Ribble Valley Borough Council  
Housing & Development Control

Application no: **3/2022/0935**

Address: **Read and Simonstone Village Hall 6 East View Read BB12 7PS**

The Local Highway Authority have viewed the plans and highway related documents and have the following comments to make:

5387 -S01C

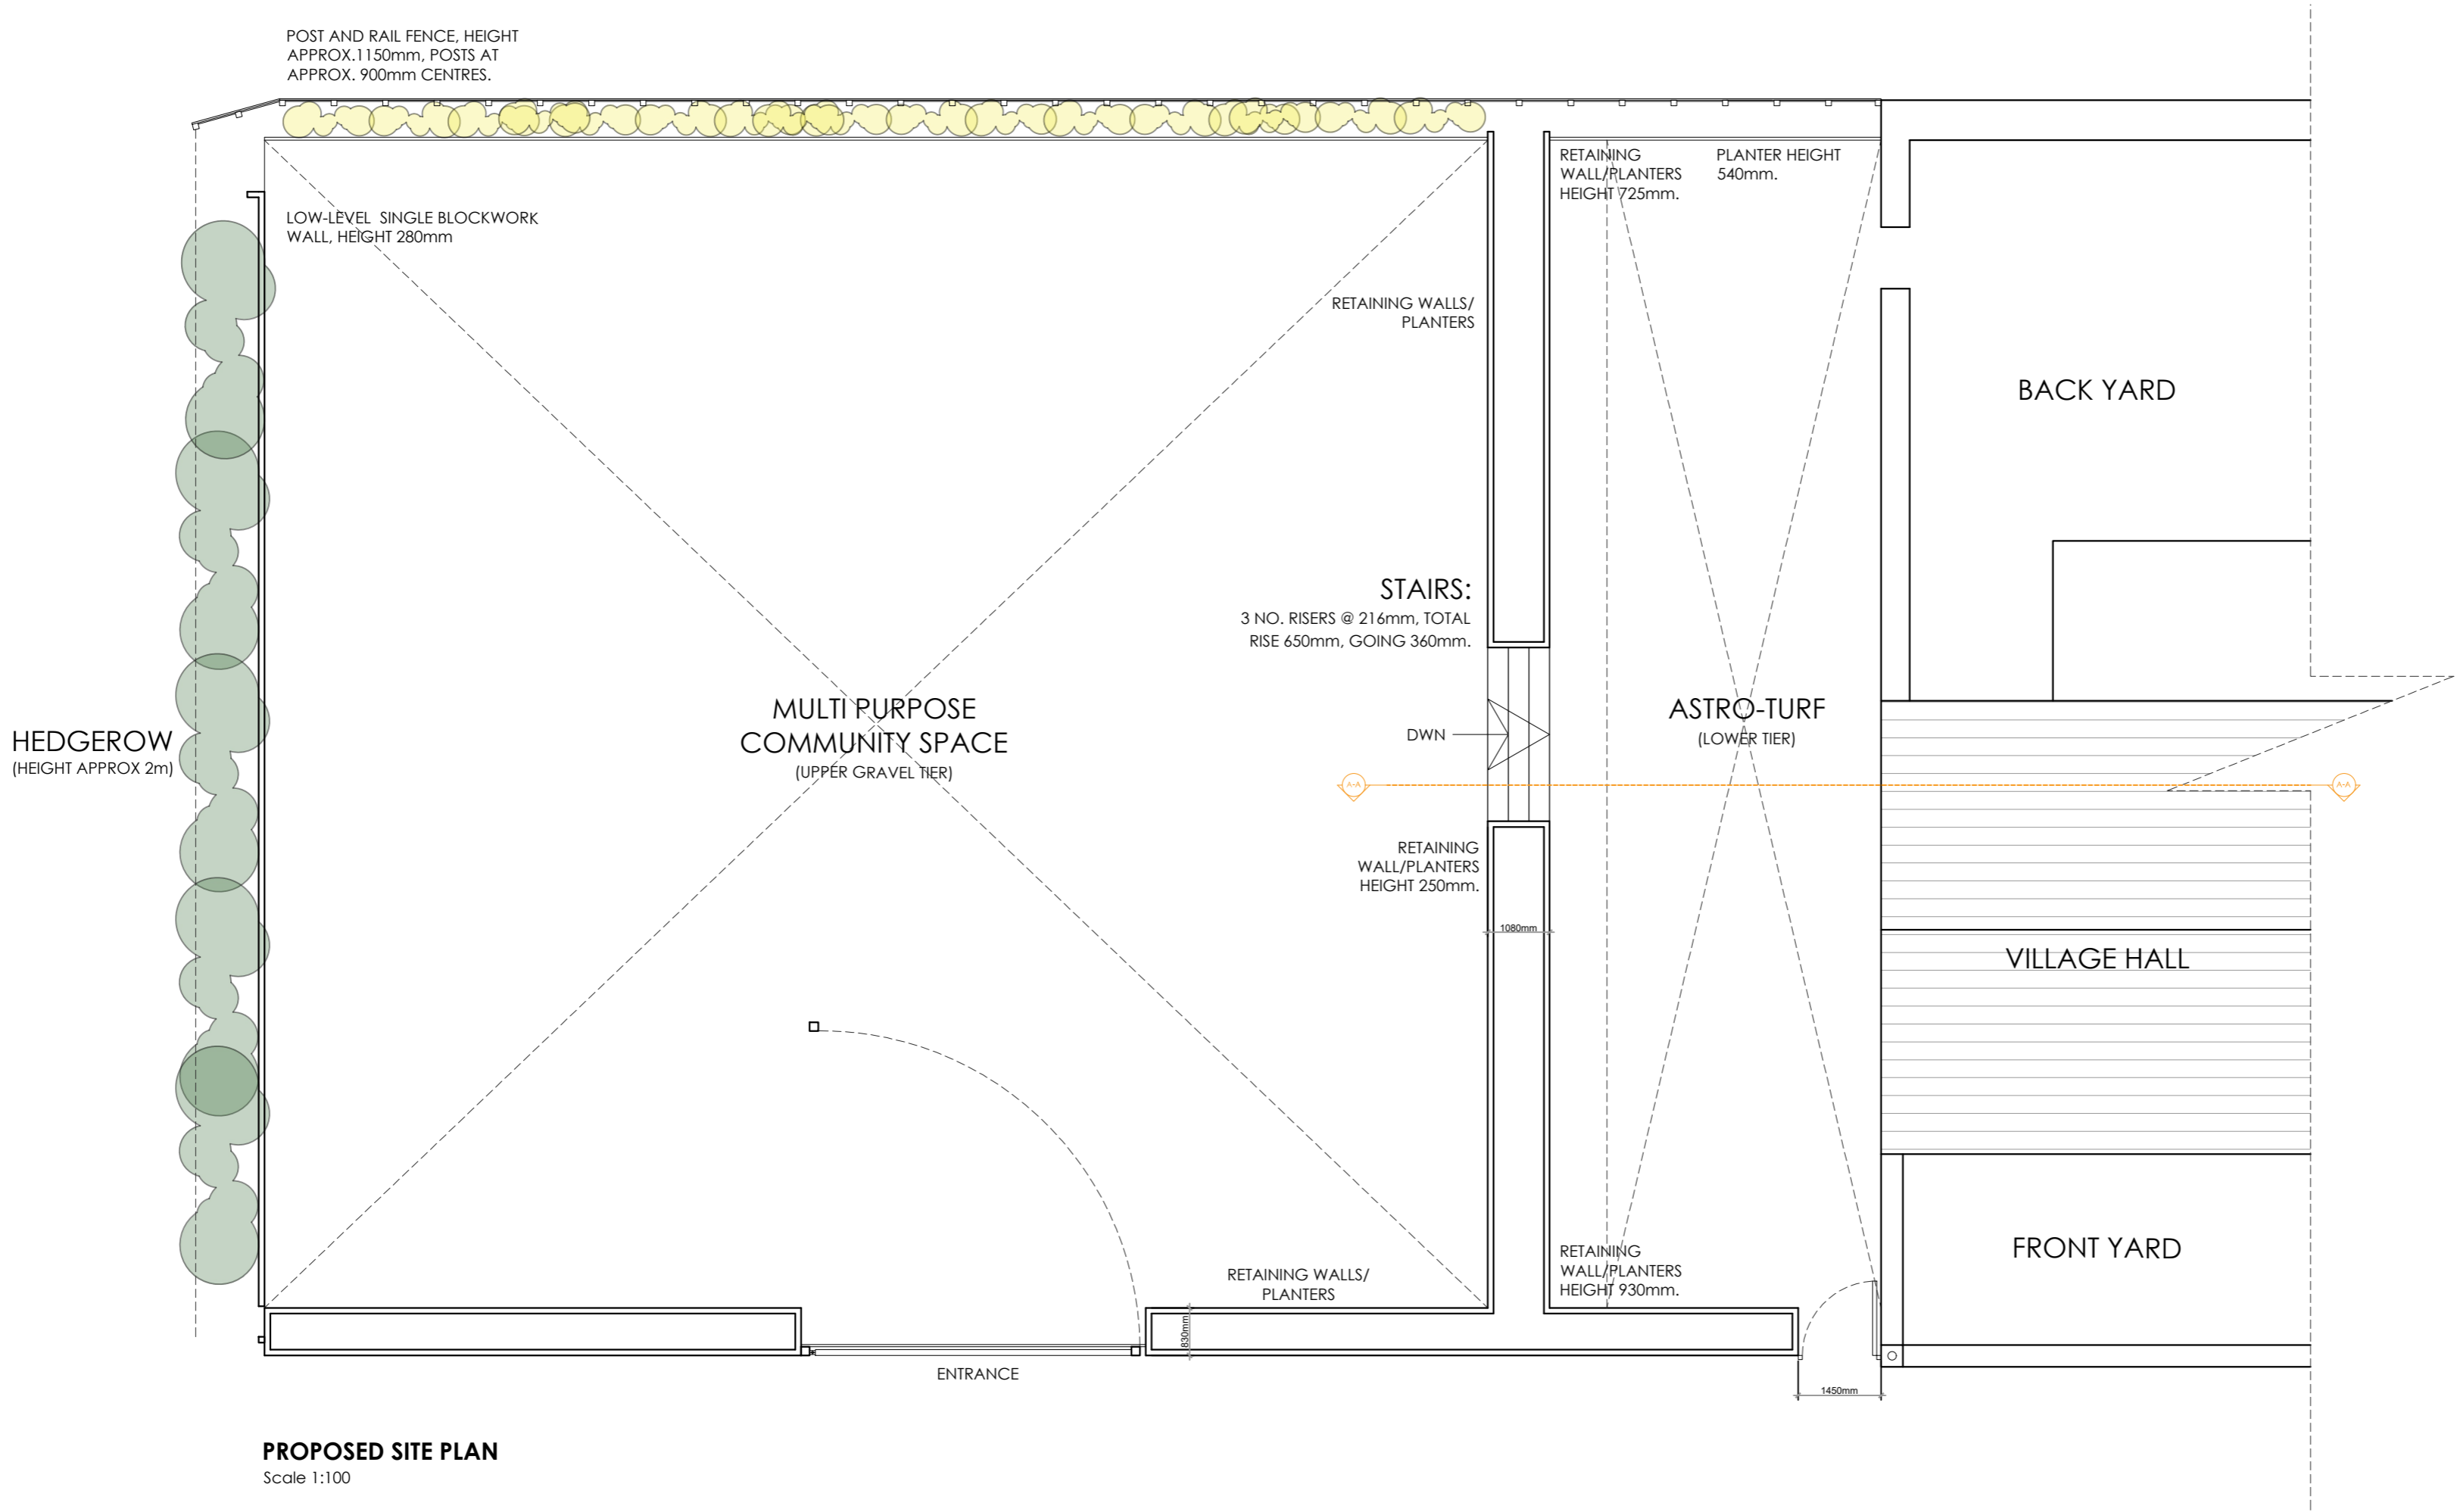
The LHA have reviewed SPA drawing number 5387-S02 titled "Proposed Site and Visibility Splay Plan" and are aware that the access will be a minimum of 6m wide, which complies with the LHAs guidance.

The LHA are also aware that the access can achieve vehicular visibility splays of 2.4m x 25m in both directions which complies with the LHAs guidance.

Furthermore, the LHA welcome the relocation of the proposed access from the crossroads junction between East View/ Tennyson Avenue/ Greenacres to a more central location which will help highway safety.

However, the LHA are aware that the gate located on the access will be setback a distance of 2.4m from the adopted highway. Usually, the LHA require a gate to be setback a minimum distance of 5m to ensure that the gate can be operated without obstructing the flow of traffic on the adopted highway.

Despite this, the LHA will accept the setback distance of the gate given that the site will be used sporadically under permitted development and due to the site being located off an unclassified road. Therefore, the LHA have no objection to the proposal.

The LHA will also request that a "H bar" is located outside of the access to prevent vehicles from obstructing the use of the access. The LHAs Operations team can implement this but the Applicant will be liable to the cost of implementing it.

1. No part of the development hereby permitted shall be occupied until such time as the access arrangements shown on SPA drawing number 5387-S02 have been implemented in full.

2. No part of the development hereby permitted shall be occupied until such time as vehicular visibility splays of 2.4 metres by 25 metres have been provided at the site access. These shall thereafter be permanently maintained with nothing within those splays higher than 1 metres above the level of the adjacent footway/verge/highway.

3. The development hereby permitted shall not be occupied until such time as the access drive (and any turning space) has been surfaced with tarmacadam, or similar hard bound material (not loose aggregate) for a distance of at least 5 metres behind the highway boundary and, once provided, shall be so maintained in perpetuity.

4. The surface water from the approved access shall be collected within the site and drained to a suitable internal outfall.
